City of Albuquerque

August 16, 2002

RE: UNITED RENTALS HIGHWAY SUPPLY CO. (E-16/D014)
(6221 Chappel Rd NE)
ENGINEERS CERTIFICATION FOR CERTIFICATE OF OCCUPANCY
ENGINEERS STAMP DATED 2/22/2001
ENGINEERS CERTIFICATION DATED 8/14/2002

C-2

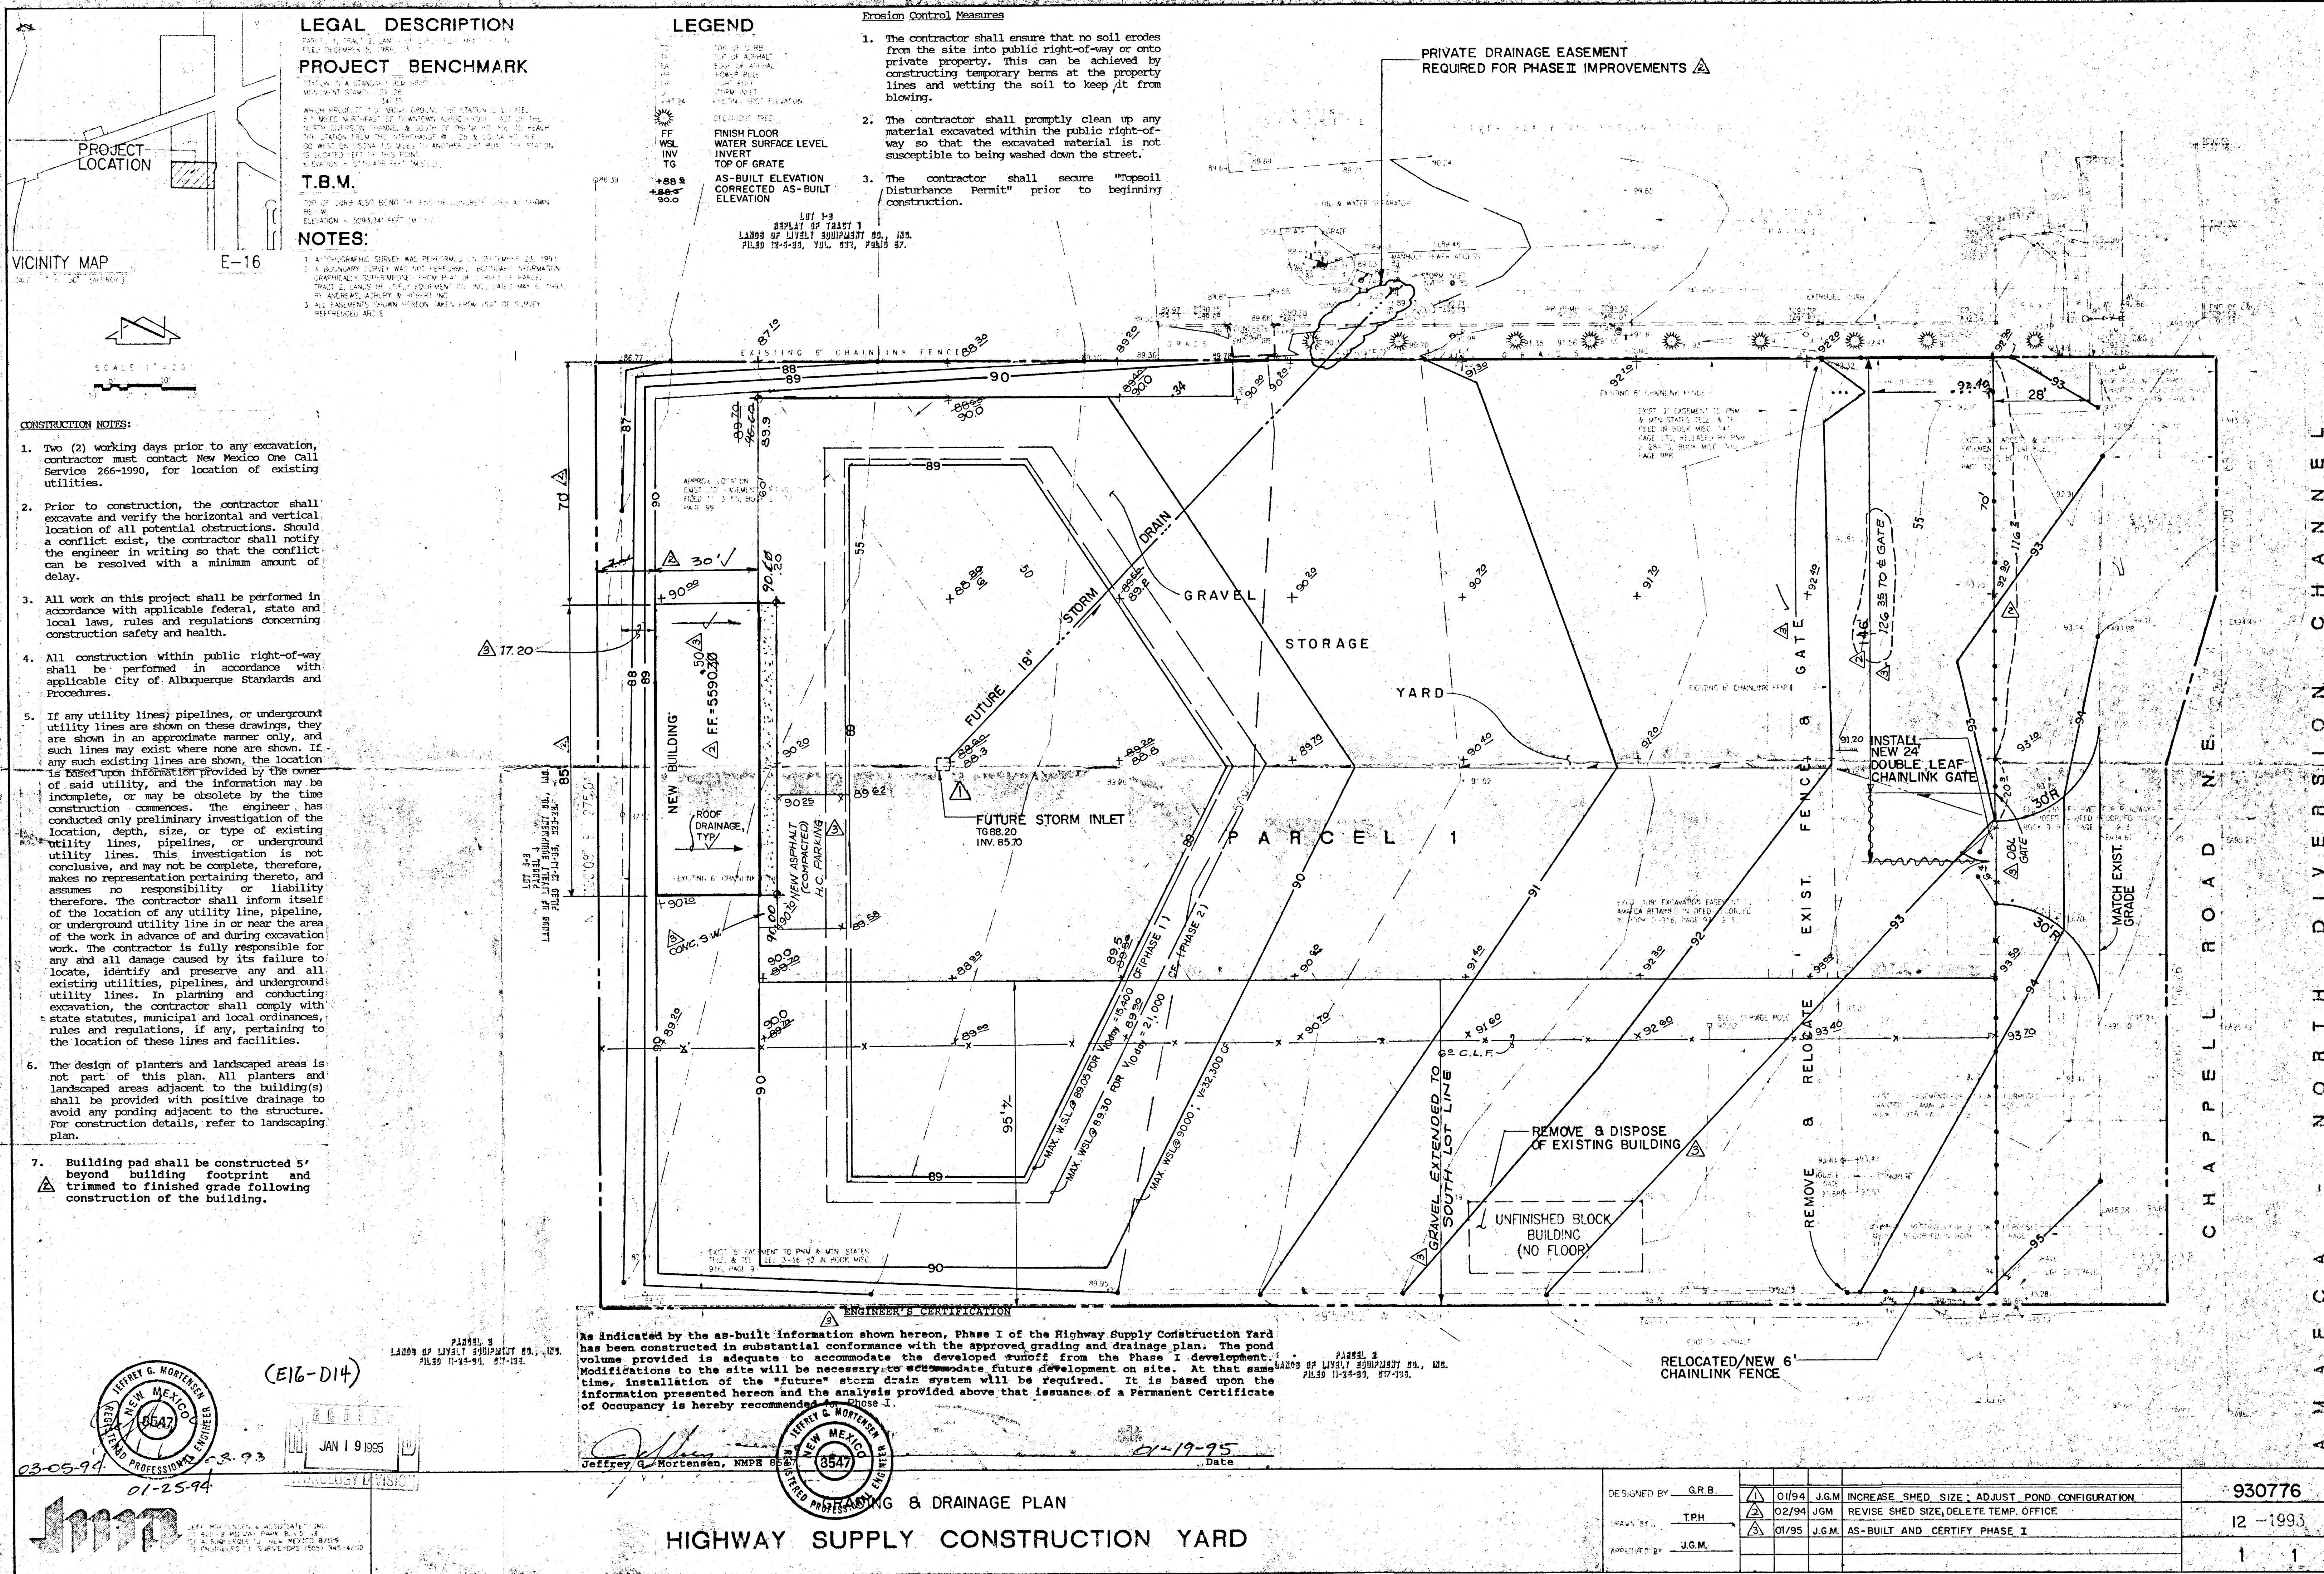
As per our phone conversation on 8/16/2002, please correct the issues we discussed pertaining to your Engineers Certification submittal.

S/W NEEDS
TO BE

INSTALLED
PRIOR TO
C.O.

RETAINING WALL E.O.V.?
F.F. E.O.V.?

PRIVATE DRAINAGE
EASEMENT?

S/W TAKEN OFFICIALS.
LIST?

DROP IN LOT IN PONDAGE?

PROPOSED ADDITION TO
SHED?

CHANGE CONT LOADING
"SUBSTANTIAL
COMPLIANCE"?

DELETE SWALE?

POOF DRAINAGE?
